Our Ref: BR/180/19/PL

**Town & Country Planning Act 1990 (as amended)
Town and Country Planning (Development Management Procedure) (England) Order 2015
Application for Full Planning Permission**

Development Erection of demountable/removable commercial unit at front facing London Road with residential unit at rear
Location 37 London Road Bognor Regis

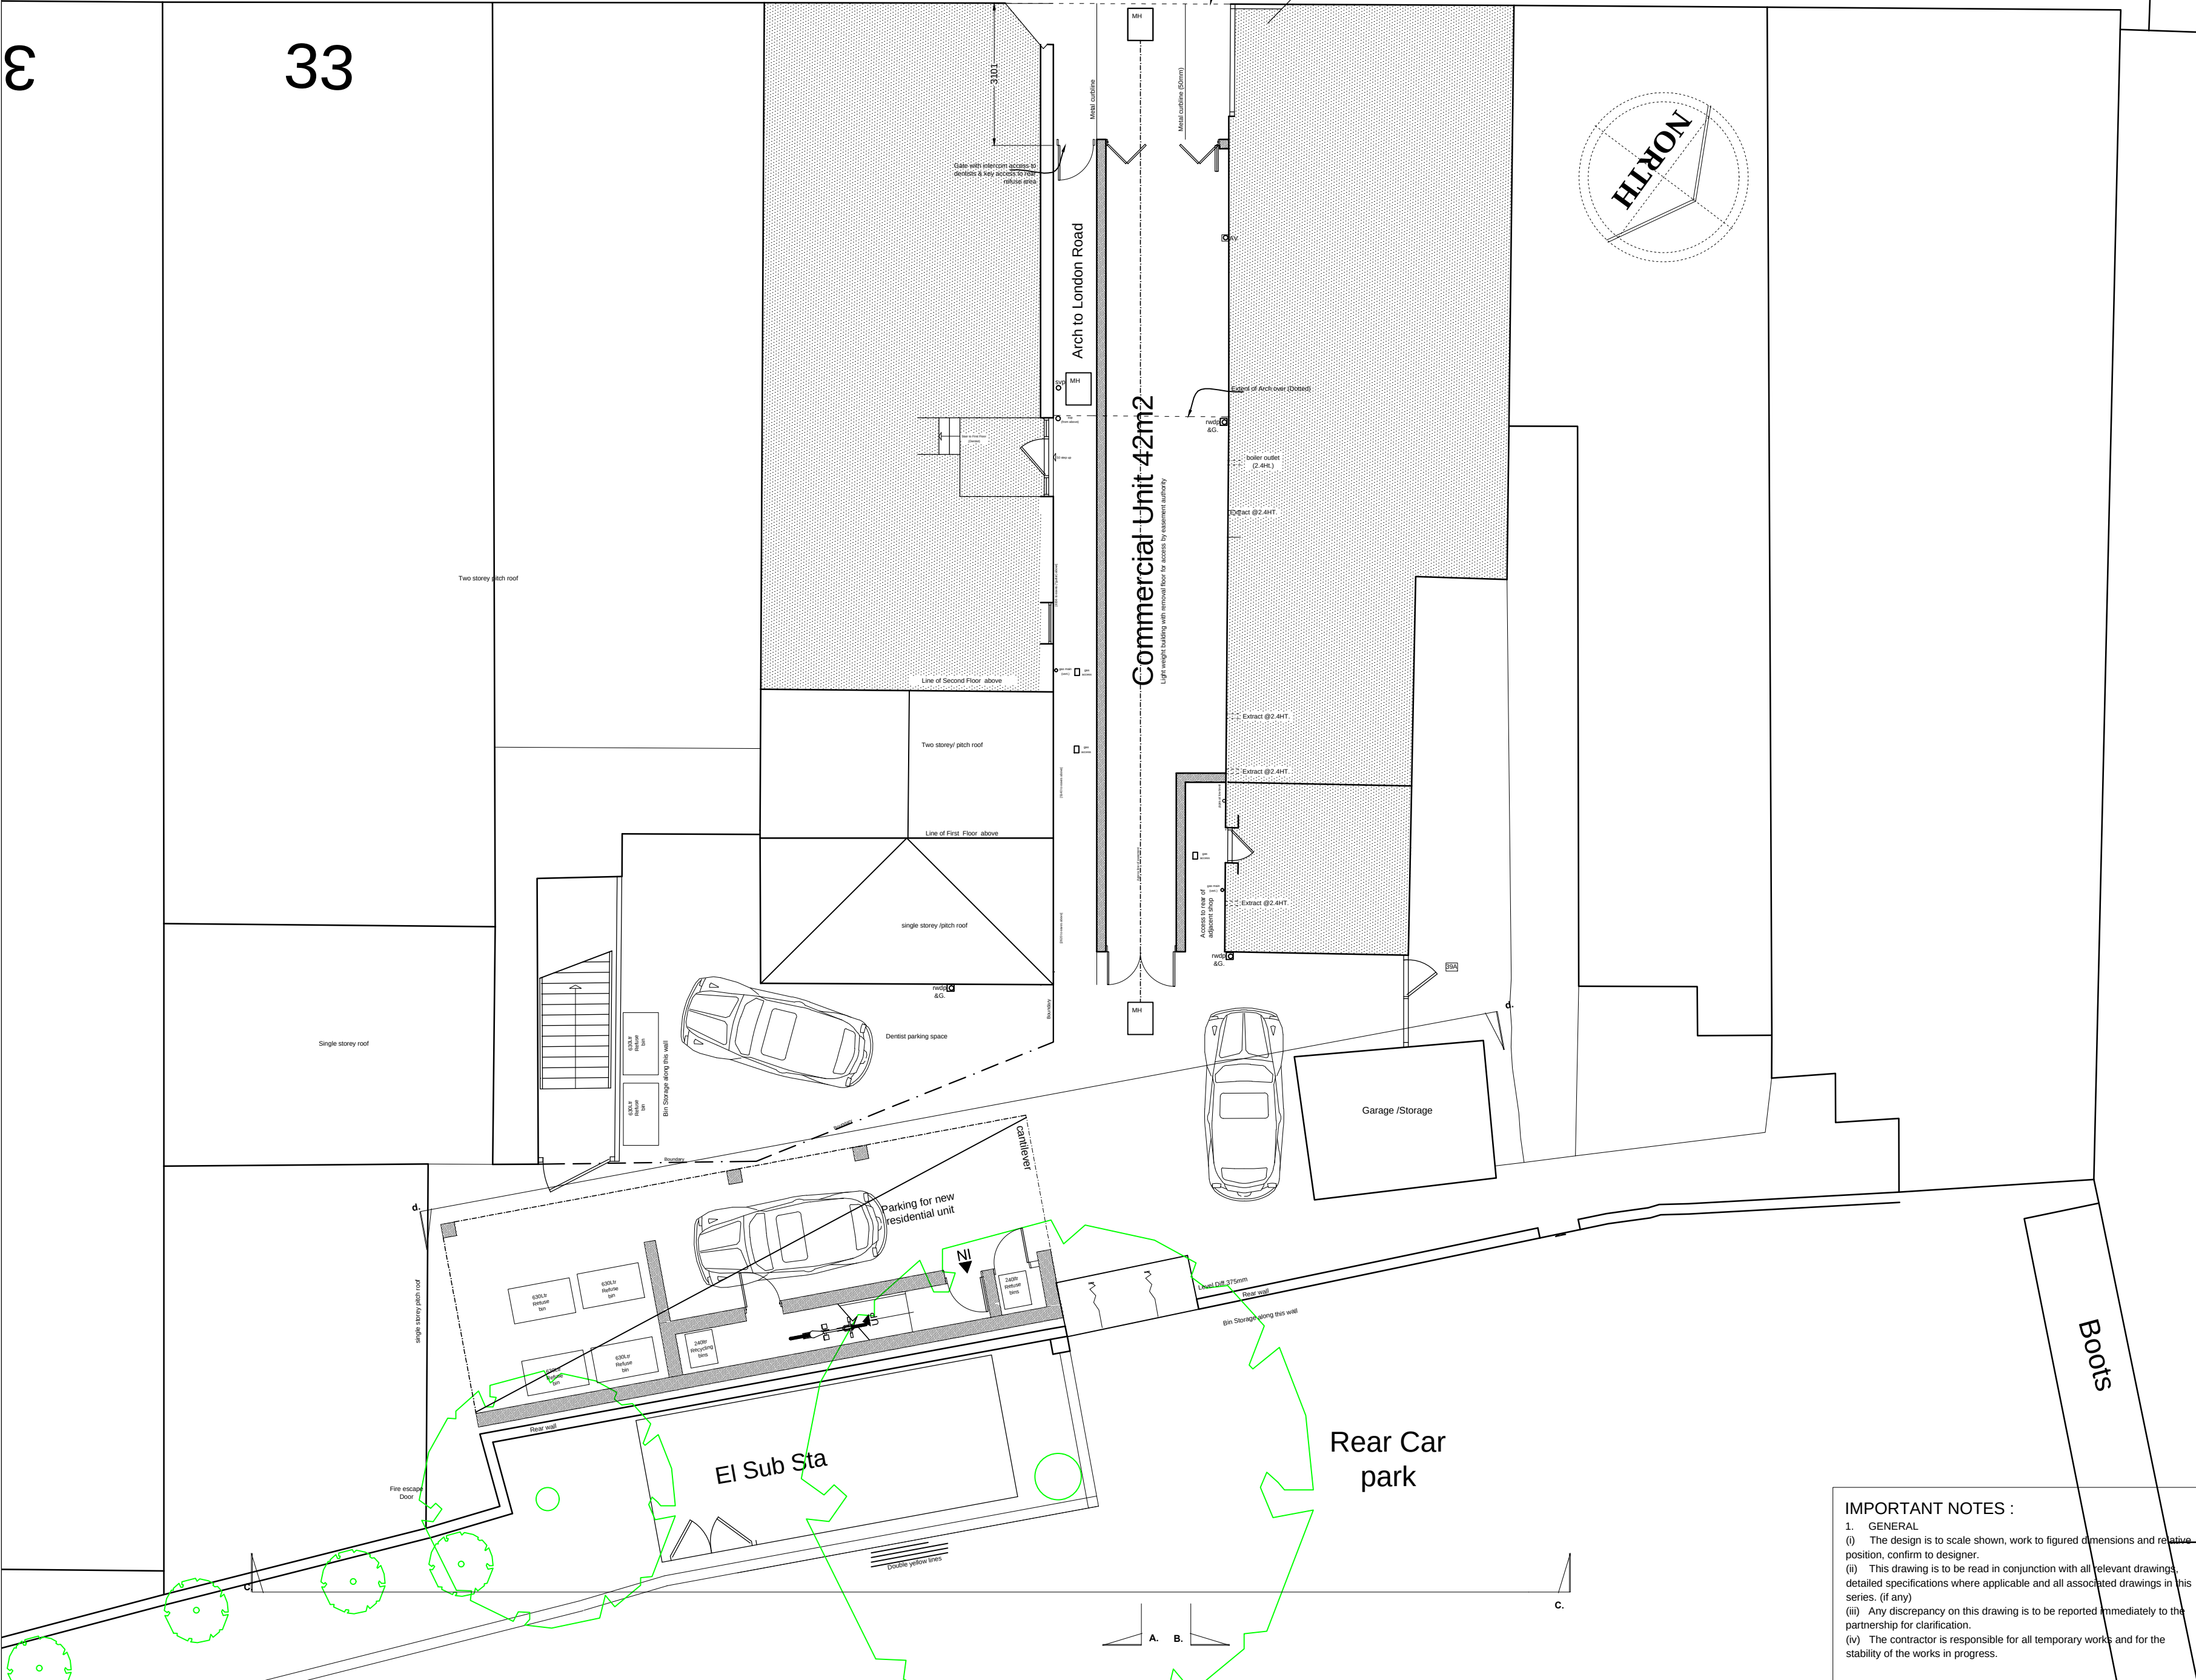
It has become apparent that the site you have red edged on your location plan, does not include access onto the Public Highway only onto the car park at the rear of the property. It is a validation requirement that the location plan shows the access to the highway and you will need to amend your location and block plans to show the access from the site to the public highway.

Dims added	Aug 19		A
Revision	Date	By	Rev. No.
Client			
Project RO 37 London Road, Bognor			
Title Block Plan			
CLIVE HAWKINS ARCHITECTS LTD DESIGN@CLIVEHAWKINSONLINE.COM Tel: 01273 245249			
Scales 1/500@ A4	Date 1.6.19	Drawn	Designer
Project No. 637	Dwg. No. Block Plan	Rev. No. A

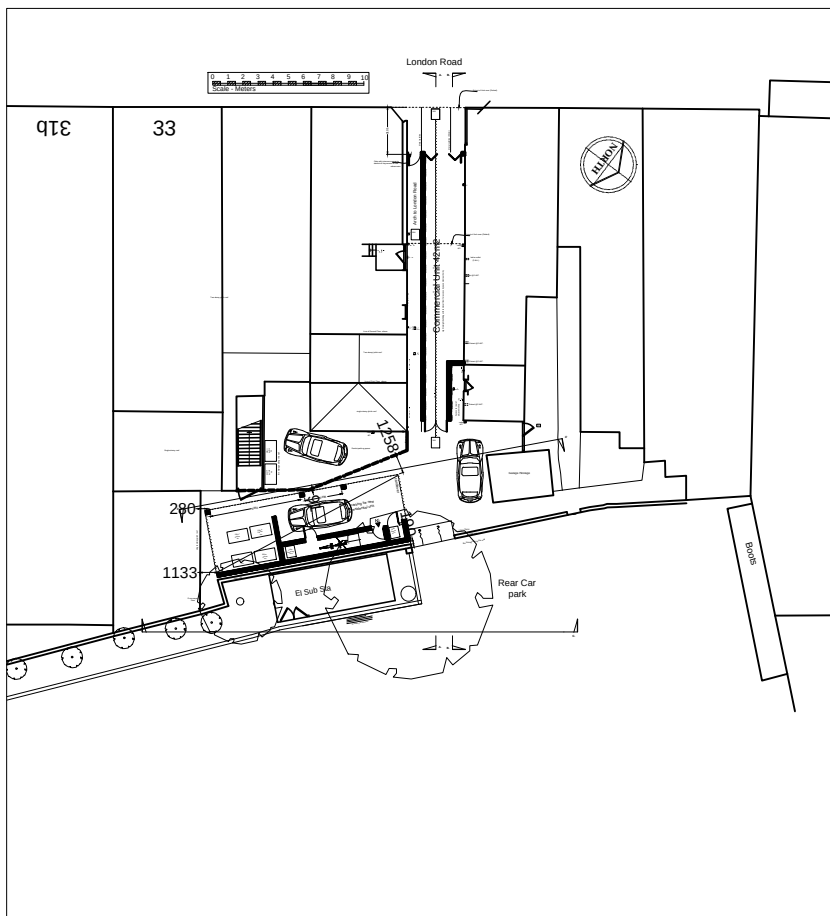
Please note that if you are amending the red edge of the site this may well alter the fee that is due as the fee is calculated on the site area. I cannot confirm this until you have submitted the amended plan.
